ADDITIONAL DRAINAGE COMMENTS AND PROPOSED WORKS		
ISSUE / ITEM	COMMENTS	ADDITIONAL WORK AND ACTIONS
SA1	IN APRIL 2025 FOUR BREKES (FULLY COMPLIANT) TESTS WERE UNDERTAKEN IN THE OPEN SPACE AREA WHERE THE CURRENT SA1 IS LOCATED. ST1 REPORT 10194 (DATED 22.07.2025). THESE TESTS WERE UNDERTAKEN BELOW THE LEVEL OF THE INSTALLED SA1. THESE TESTS WERE UNDERTAKEN IN THE OPEN SPACE AREA WHERE THE CURRENT SA1 IS LOCATED. ST1 REPORT 10194 (DATED 22.07.2025). THESE TESTS WERE UNDERTAKEN BELOW THE LEVEL OF THE INSTALLED SA1. THESE TESTS WERE UNDERTAKEN IN THE OPEN SPACE AREA WHERE THE CURRENT SA1 IS LOCATED. ST1 REPORT 10194 (DATED 22.07.2025). THESE TESTS WERE UNDERTAKEN BELOW THE LEVEL OF THE INSTALLED SA1.	ENTIRE SA1 (INCLUDING MAINTENANCE MANHOLES AND PERFORATED PIPES) TO BE RECONSTRUCTED BY A NEW 1000mm x 1.2m HAOD. THE AN AREA IS PRESENTED ON THE DRAINAGE DRAWING AND WAS TESTED AS PER DEVELOPMENT TESTS. FROM THE APRIL 2025 TESTS THE WORST INFILTRATION RATE WAS ADOPTED FOR THE CALCULATION OF THE DRAINAGE SA1. APPROVED 2025 TESTS (INCLUDING SHOWN FULLY) FOLLOWING BREKES INFILTRATION AND A LARGE NUMBER OF BREKES TESTING MITIGATED THE UNCERTAINTY OF INFILTRATION POTENTIAL WITH BETTER INFILTRA

DRAINAGE (SHEET 1)

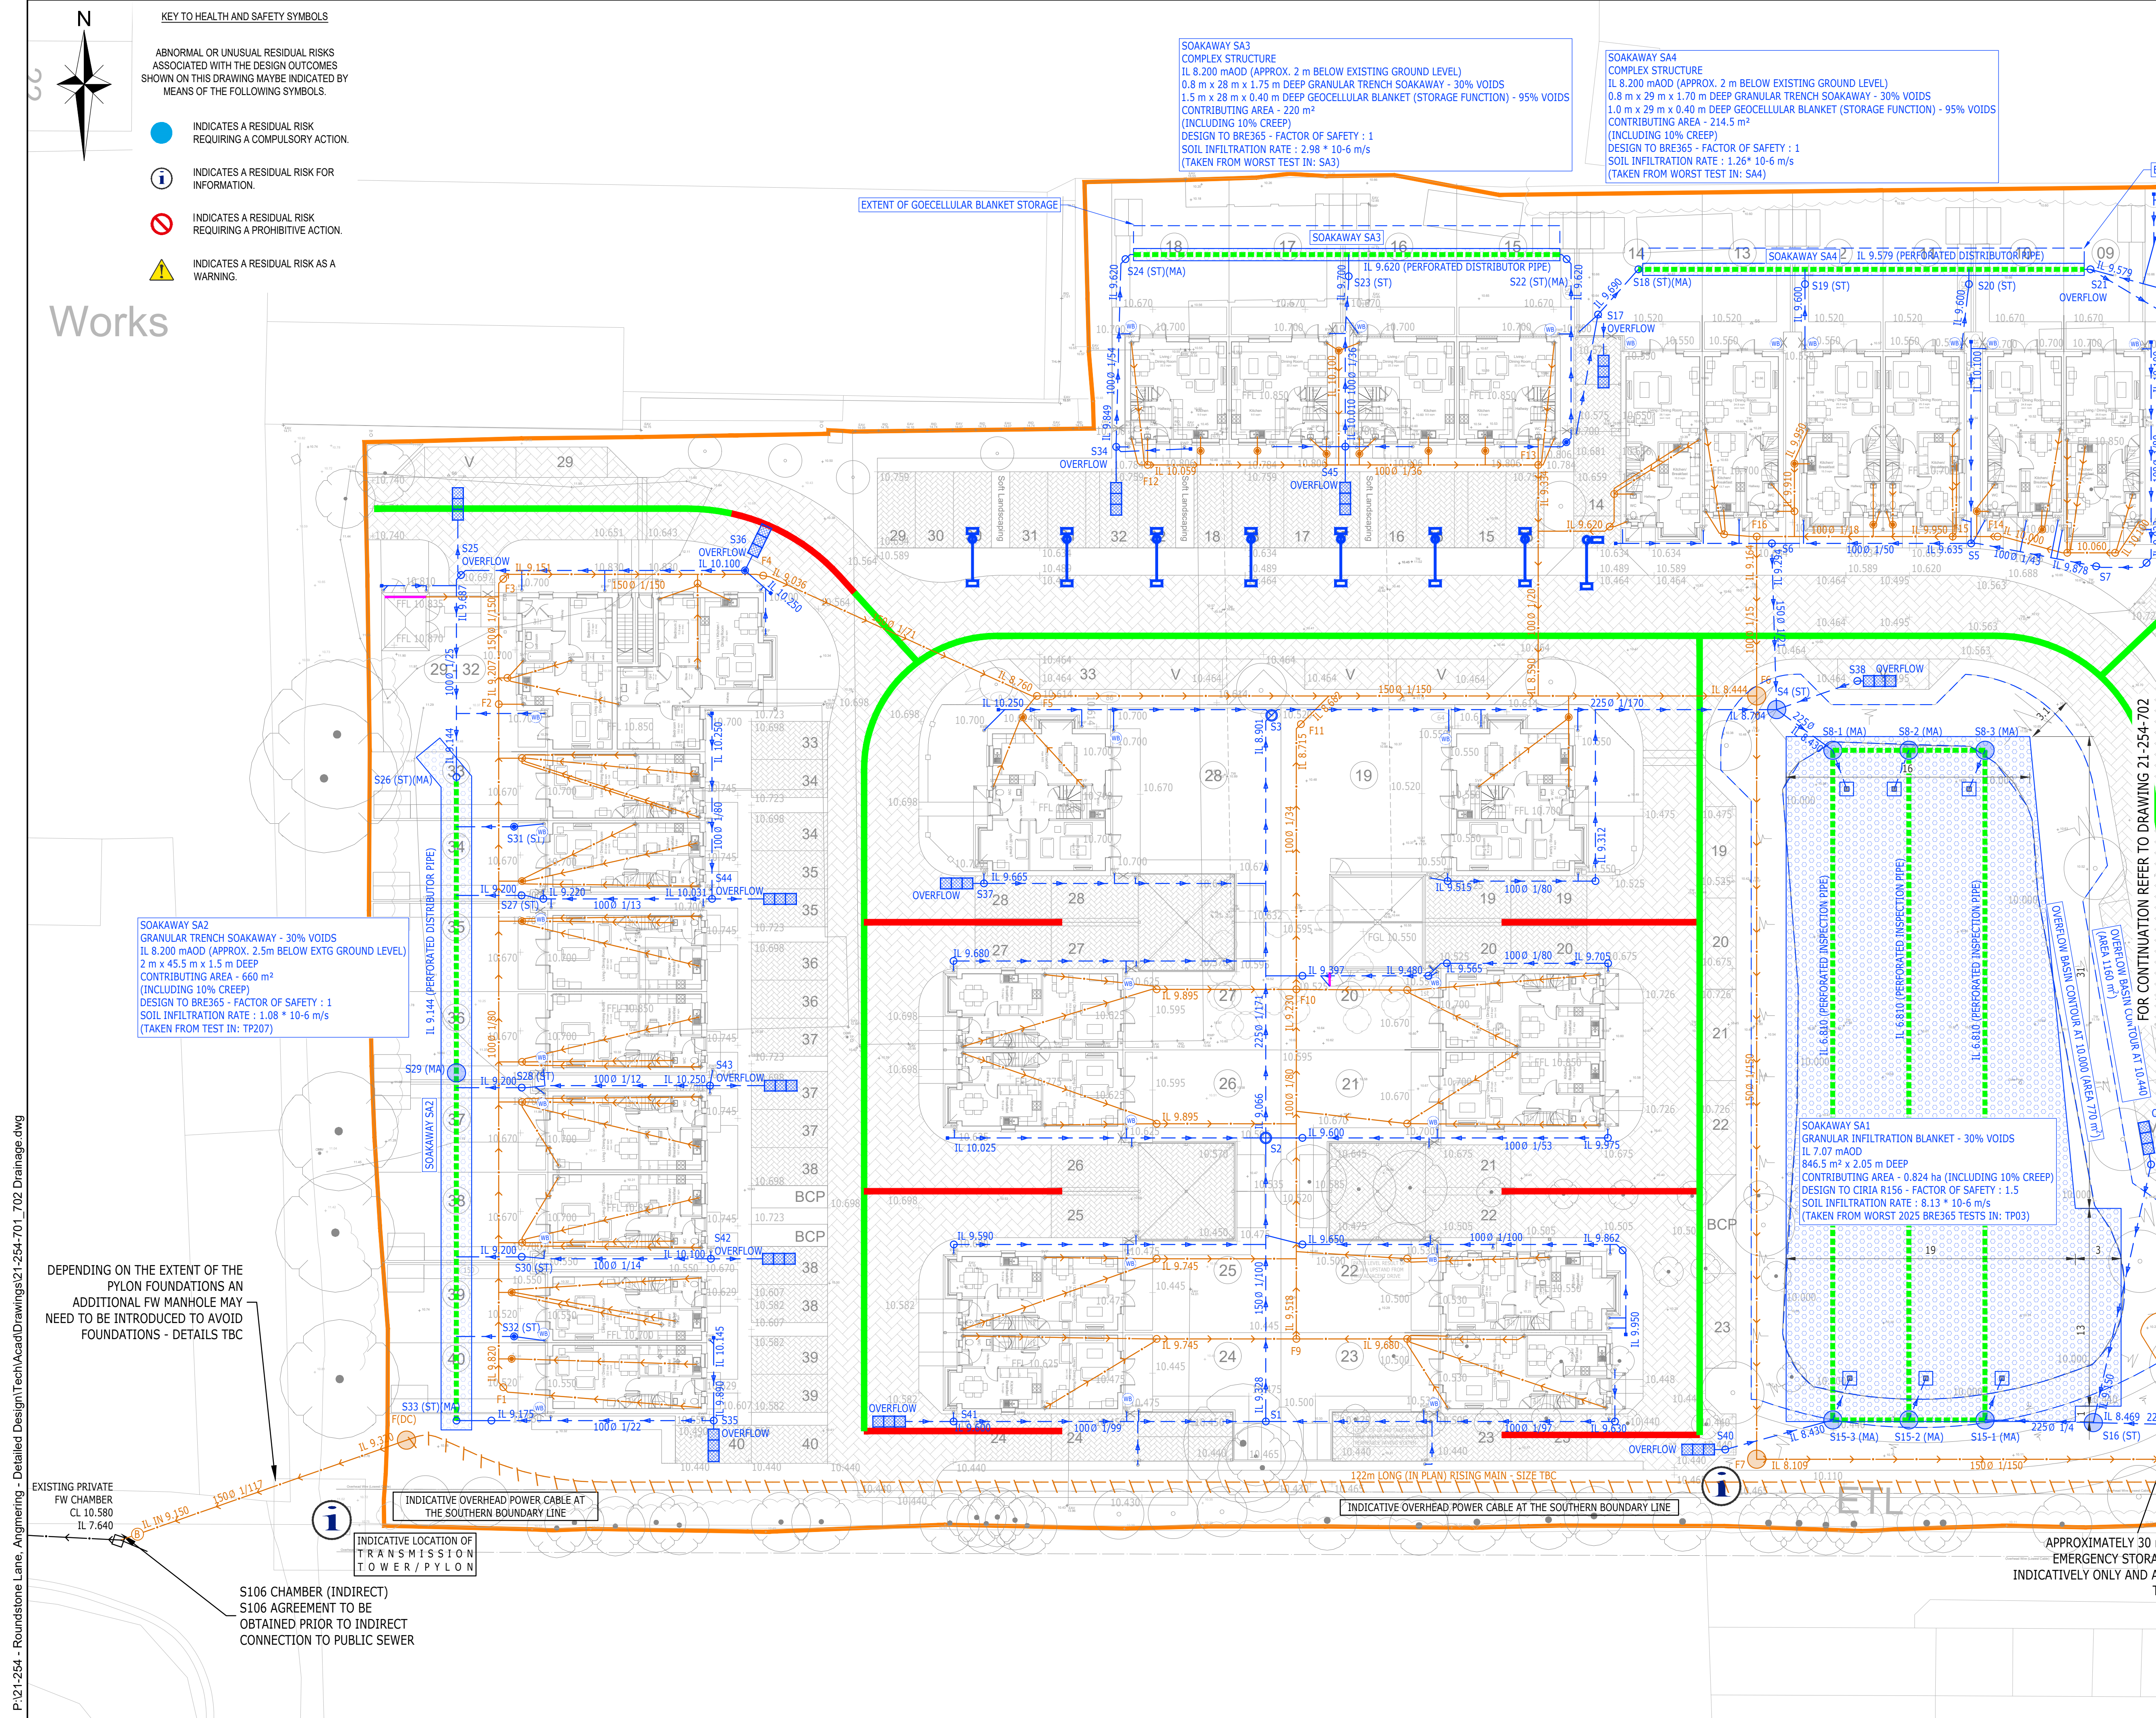
SA2	SA2 STRUCTURE IS TO REMAIN IN-SITU AS INSTALLED. PRE-DEV BREKES TESTING BY LEAP (REPORT LK2368 AND SC20240701) PROVIDED THAT LOCAL AREA AND INFILTRATION POTENTIAL THEREFORE WATER ACCUMULATED WITHIN SA2 WOULD INFILTRATE INTO THE SURROUNDING SOIL WITH TIME. HOWEVER, TO IMPROVE THE OVERALL DRAINAGE SITUATION AND FEASIBILITY FOR THE SITE IT IS PROPOSED TO UNDERTAKE FURTHER ACTIONS.	IGNORING INFILTRATION POTENTIAL OF SA2 IT IS PROPOSED TO INSTALL OVERFLOW FROM THE SW SYSTEM - CURRENTLY CONNECTED TO SA2 - AND OVERFLOW WATER INTO THE PERMEABLE PAVING SYSTEM AND THENCE TO SA1. WITH THIS REVISED DRAINAGE ARRANGEMENT SHOULD SA2 INFILTRATION POTENTIAL AND FILL WATER WOULD BE DIRECTED TO SA1 AND THIS NOT INCREASE FLOODING RISK ON OR OFF SITE.
SA3 AND SA4	SA3 AND SA4 STRUCTURES ARE TO REMAIN IN-SITU AS INSTALLED. SA3 AND SA4 WERE RE-TESTED AS INSTALLED IN APRIL 2025. ST1 REPORT 10194 (DATED 22.07.2025). TESTING PROVIDED THAT LOCAL AREA HAS INFILTRATION POTENTIAL THEREFORE WATER ACCUMULATED WITHIN SA3 AND SA4 WOULD INFILTRATE INTO THE SURROUNDING SOIL WITH TIME. HOWEVER, TO IMPROVE THE OVERALL DRAINAGE SITUATION AND FEASIBILITY FOR THE SITE IT IS PROPOSED TO UNDERTAKE FURTHER ACTIONS.	IGNORING INFILTRATION POTENTIAL OF SA3 AND SA4 IT IS PROPOSED TO INSTALL OVERFLOW FROM THE SW SYSTEM - CURRENTLY CONNECTED TO SA3 OR SA4 - AND OVERFLOW WATER INTO THE PERMEABLE PAVING SYSTEM AND THENCE TO SA1. WITH THIS REVISED DRAINAGE ARRANGEMENT SHOULD SA3 AND SA4 INFILTRATION POTENTIAL WAS TO FILL WATER WOULD BE DIRECTED TO SA1 AND THIS NOT INCREASE FLOODING RISK ON OR OFF SITE.

PERMEABLE PAVING (PP)	PP STRUCTURE IS TO REMAIN IN-SITU AS INSTALLED. PRE-DEV BREKES TESTING BY LEAP (REPORT LK2368 AND SC20240701) PROVIDED THAT LOCAL AREA AND INFILTRATION POTENTIAL THEREFORE WATER ACCUMULATED WITHIN PP WOULD INFILTRATE INTO THE SURROUNDING SOIL WITH TIME. HOWEVER, TO IMPROVE THE OVERALL DRAINAGE SITUATION AND FEASIBILITY FOR THE SITE IT IS PROPOSED TO UNDERTAKE FURTHER ACTIONS.	IGNORING INFILTRATION POTENTIAL OF PP IT IS PROPOSED TO INSTALL OVERFLOW FROM THE SW SYSTEM - CURRENTLY CONNECTED TO SA3 OR SA4 - AND OVERFLOW WATER INTO THE PERMEABLE PAVING SYSTEM AND THENCE TO SA1. WITH THIS REVISED DRAINAGE ARRANGEMENT SHOULD SA3 AND SA4 INFILTRATION POTENTIAL WAS TO FILL WATER WOULD BE DIRECTED TO SA1 AND THIS NOT INCREASE FLOODING RISK ON OR OFF SITE.
OVERFLOW BASIN (OBS)	THIS BASIN IS PROVIDED FOR THE SURFACE WATER VOLUMES OVERFLOWING FROM THE ACTUAL SA1 STRUCTURE AND FOLLOWING THE EXISTING DRAINAGE.	THE OVERFLOW BASIN MUST BE REINSTATED FOLLOWING SA1 RECONSTRUCTION. BASIN IS TO BE INSTALLED TO ITS BASE IS FLAT AND SET AT A LEVEL OF 10.440m WITH THE BASE AREA OF PROPOSED 10.440m. THE TOP BANK IS TO BE SET NOT LOWER THAN 10.44m HAD WITH THE TOP BANK FLAT AREA MEASURING PROPERLY AS WHEN MEASURED AT A LEVEL (CONTOUR) OF 10.44m HAD.

SA1	SA1 TO BE ALTERED TO ALLOW A CONNECTION FROM THE NEARBY PERMEABLE PAVING OVERFLOW ARRANGEMENT - SEE DRAINAGE LAYOUT.	
S18	S18 MANHOLES TO BE REINSTALLED AS PART OF THE SA1 RECONSTRUCTION - SEE DRAINAGE LAYOUT AND CONSTRUCTION DETAIL.	
S15	S15 MANHOLES TO BE REINSTALLED AS PART OF THE SA1 RECONSTRUCTION - SEE DRAINAGE LAYOUT AND CONSTRUCTION DETAIL.	
S16	S16 TO BE ALTERED TO ALLOW A CONNECTION FROM THE NEARBY PERMEABLE PAVING OVERFLOW ARRANGEMENT - SEE DRAINAGE LAYOUT.	
S17, S21, S25, S24, S25, S26, S42, S43, S44, S45	CHAMBER TO BE ALTERED TO CREATE AN OVERFLOW CONNECTION INTO THE NEARBY PERMEABLE PAVING SYSTEM SUB-BASE. OVERFLOW CONNECTION TO TERMINATE BY MEANS OF DIFFUSER UNITS, I.E. PERMAVOID OR SIMILAR SUITABLE.	
S37, S41	EXISTING CHAMBER TO BE ALTERED TO RECEIVE THE PIPED CONNECTION FROM THE NEARBY PP OVERFLOW ARRANGEMENT.	
S38, S39, S40	NEW CHAMBERS TO BE INSTALLED TO RECEIVE THE PIPED CONNECTION FROM THE PP OVERFLOW ARRANGEMENT.

WB	WATER BUTTS TO BE ADDED
